Meadowlake Industrial Park
Filing No. 1 Preliminary Plan
Traffic Impact Study
(LSC #S234040)
September 24, 2023

Add PCD File No. SP236 ¹

LSC responses to TIS Redline Comments

Figure 7  
**2025 Total Traffic,  
 Lane Geometry, Traffic  
 Control, and Level of Service**  
 Meadowlake Industrial Park Filing No. 1 Preliminary Plan (LSC #S234040)

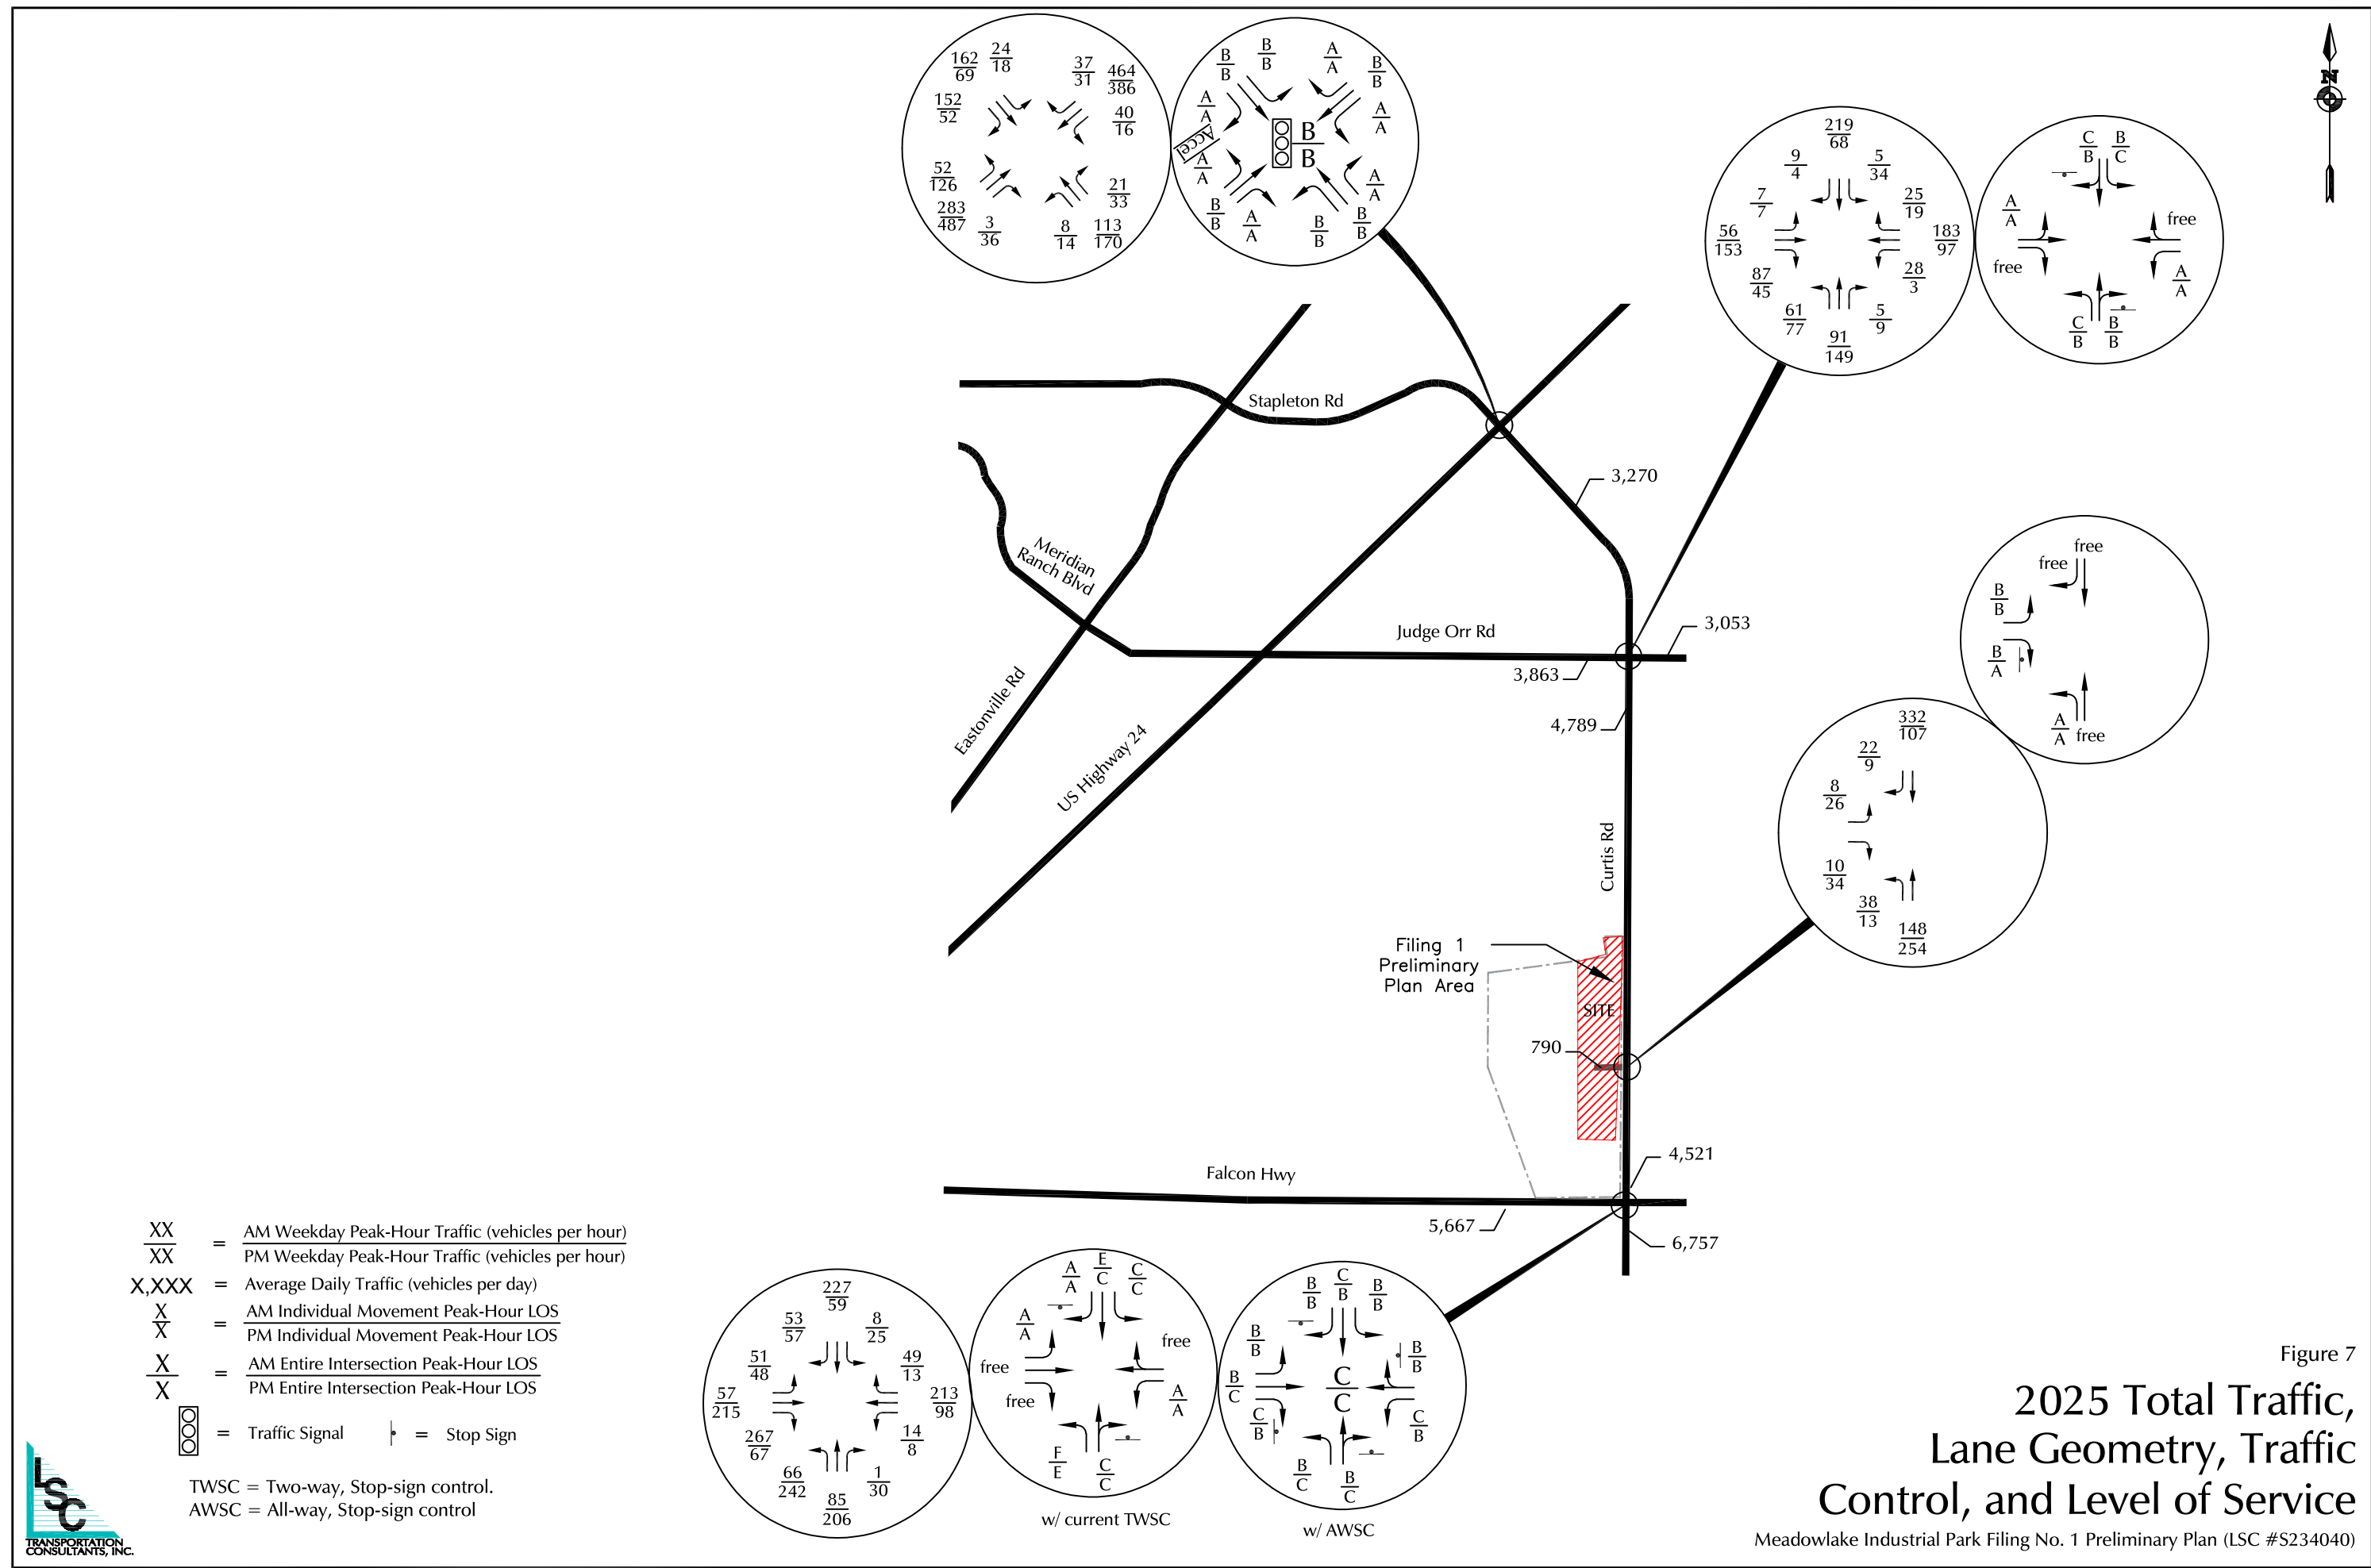
also provide the short term total lane geometry, traffic control and LOS

LSC Response: Added in the updated TIS. The updated TIS contains new and revised figures with changes to the numbering.
